20 November 2019

**Our Ref:** N-18047

**RE: NIHON UNIVERSITY NEWCASTLE CAMPUS (SSD-9787) - RESPONSE TO INFORMATION REQUEST**

DRAWING:	<b>LANDSCAPE PLAN - 1ST FLOOR</b>
PROJECT NUMBER:	1691
SHEET:	05 OF 07

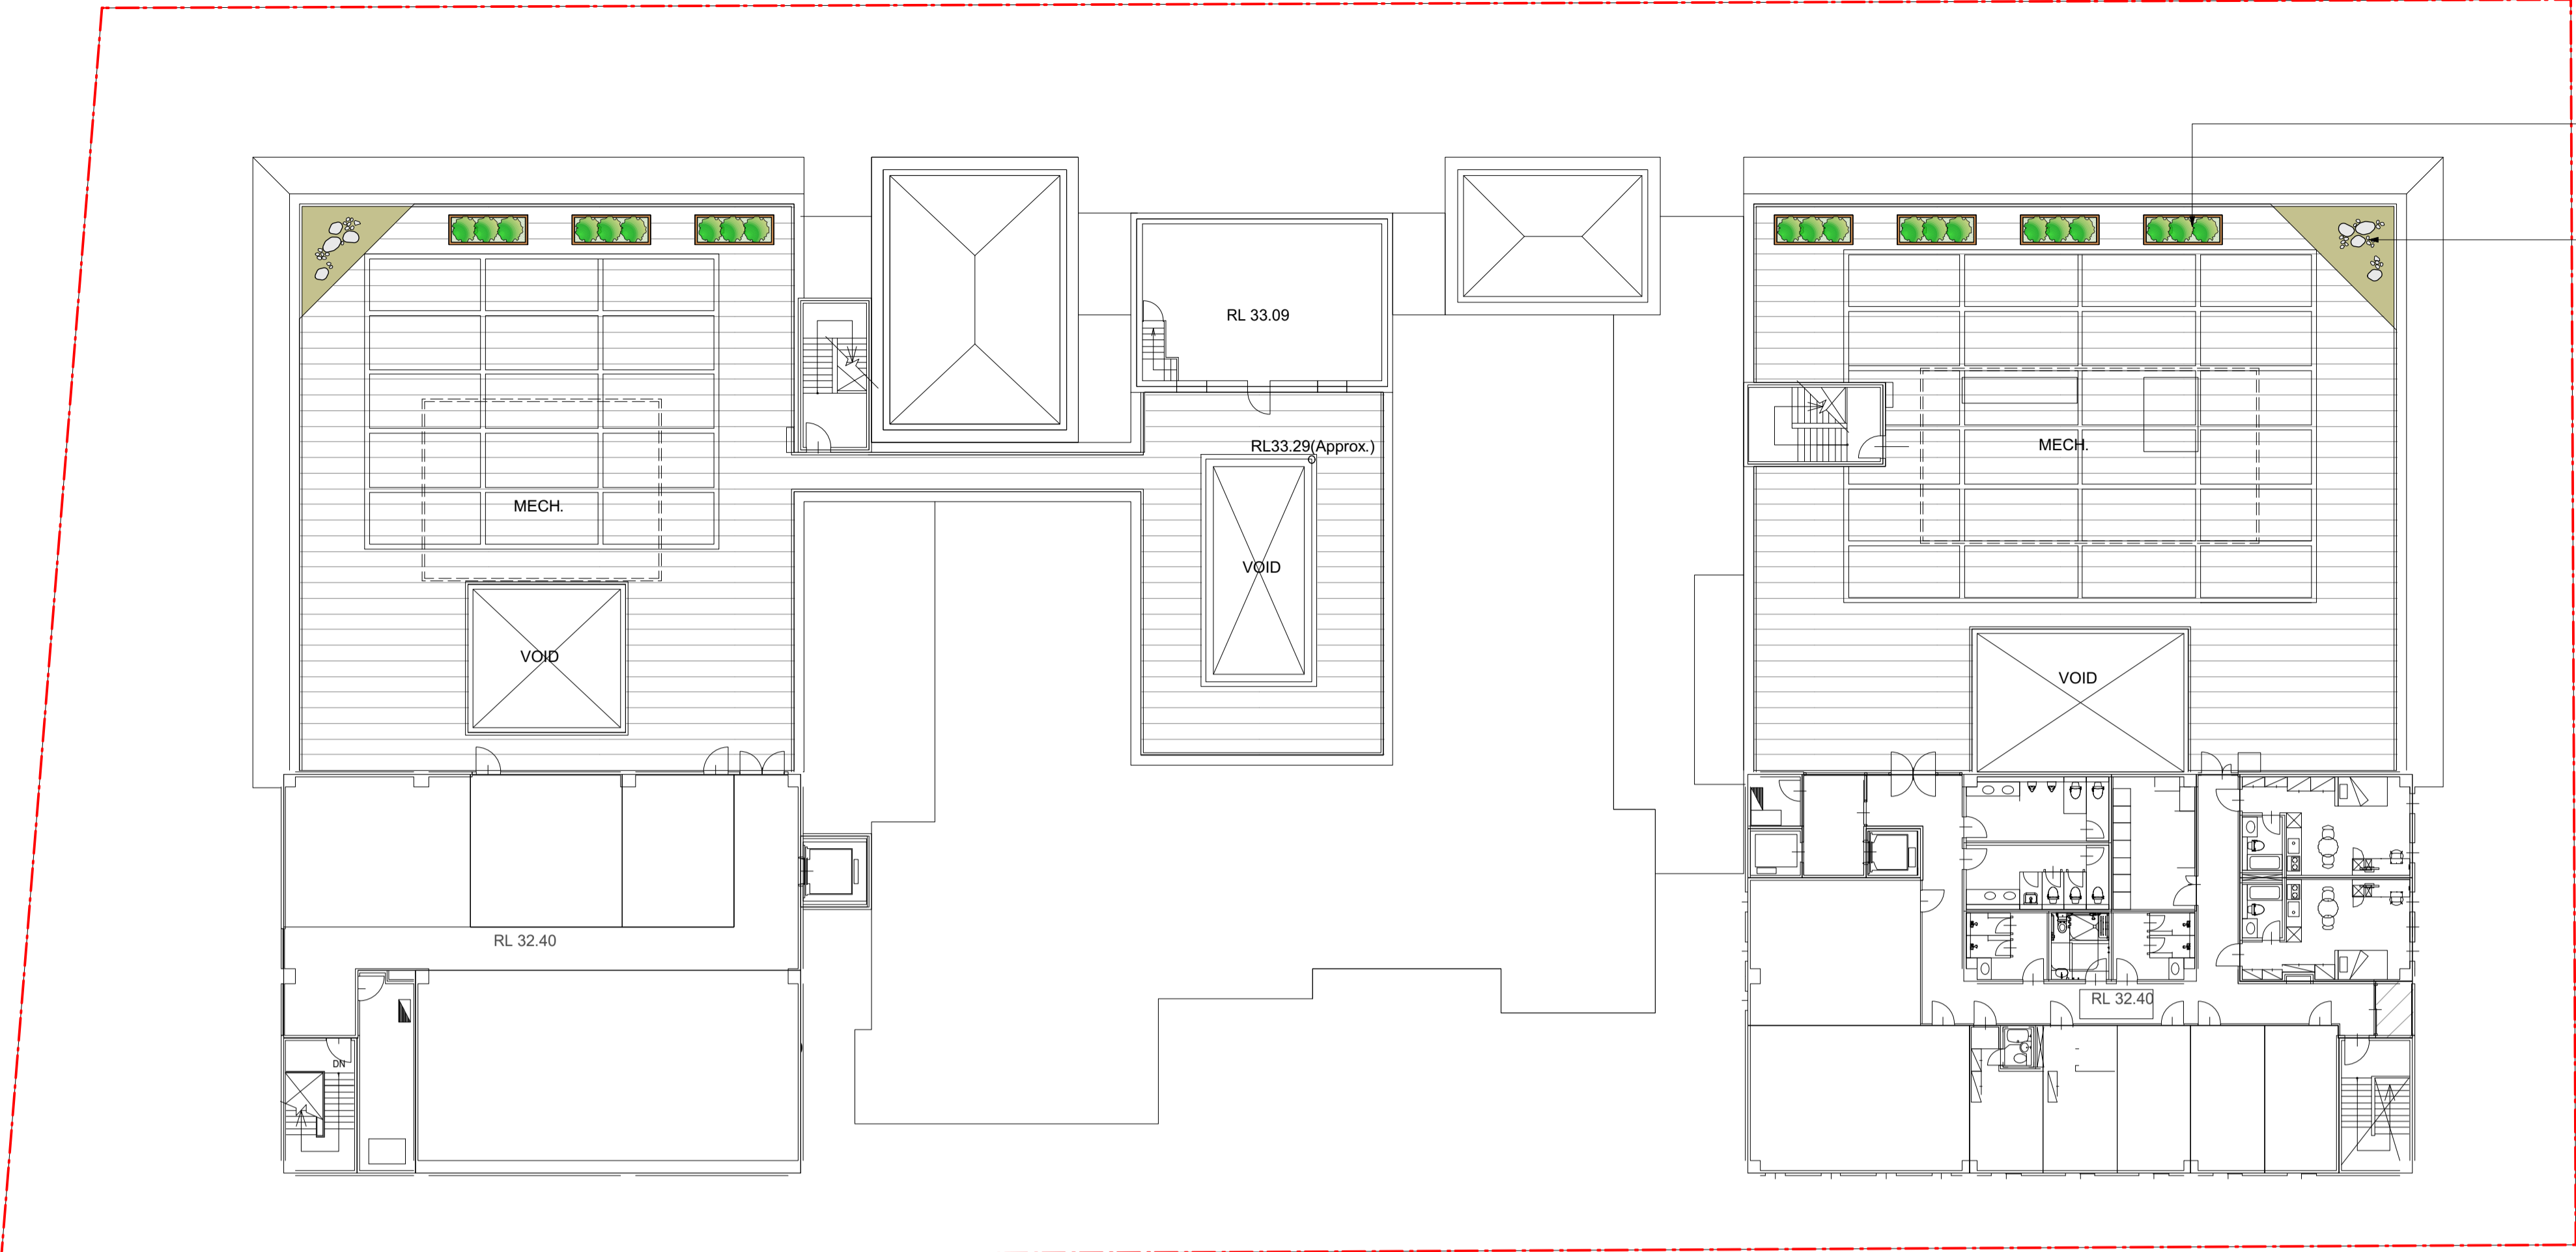
Plan / Drawing	Changes (as clouded)	Appendix
Cover Sheet (LP01 - Rev E, 19.11.2019)	<ul style="list-style-type: none"><li>▪ Updated drawing schedule</li></ul>	1a
1st Floor (LP05 - Rev E, 19.11.2019)	<ul style="list-style-type: none"><li>▪ Amendments to include the new service vehicle driveway arrangement, including entry, exit and hardstand</li><li>▪ Removal of existing street tree to accommodate the new service vehicle exit and replacement with new street tree of the same species (<i>Magnolia grandiflora</i> 'Little Gem')</li></ul>	1b

<ul style="list-style-type: none"> <li>▪ Inclusion of removable bollards for service vehicle zone entry/exit</li> <li>▪ Heavy duty concrete paving for the service vehicle zone</li> <li>▪ Minor relocation of Fire Hydrant booster and signage wall, as well as amendments to locations of soft landscaping</li> <li>▪ Sandstone paving to main pedestrian entrance</li> </ul>	
1st Floor (LP06 - Rev E, 19.11.2019)	<ul style="list-style-type: none"> <li>▪ Removal of existing street tree to accommodate the new service vehicle exit and replacement with new street tree of the same species (<i>Magnolia grandiflora</i> 'Little Gem')</li> <li>▪ Minor relocation of Fire Hydrant booster and signage wall</li> </ul>	1c
Planting & Theming Palette (LP07 - Rev E, 19.11.2019)	<ul style="list-style-type: none"> <li>▪ New street tree of the same species (<i>Magnolia grandiflora</i> 'Little Gem')</li> </ul>	1d
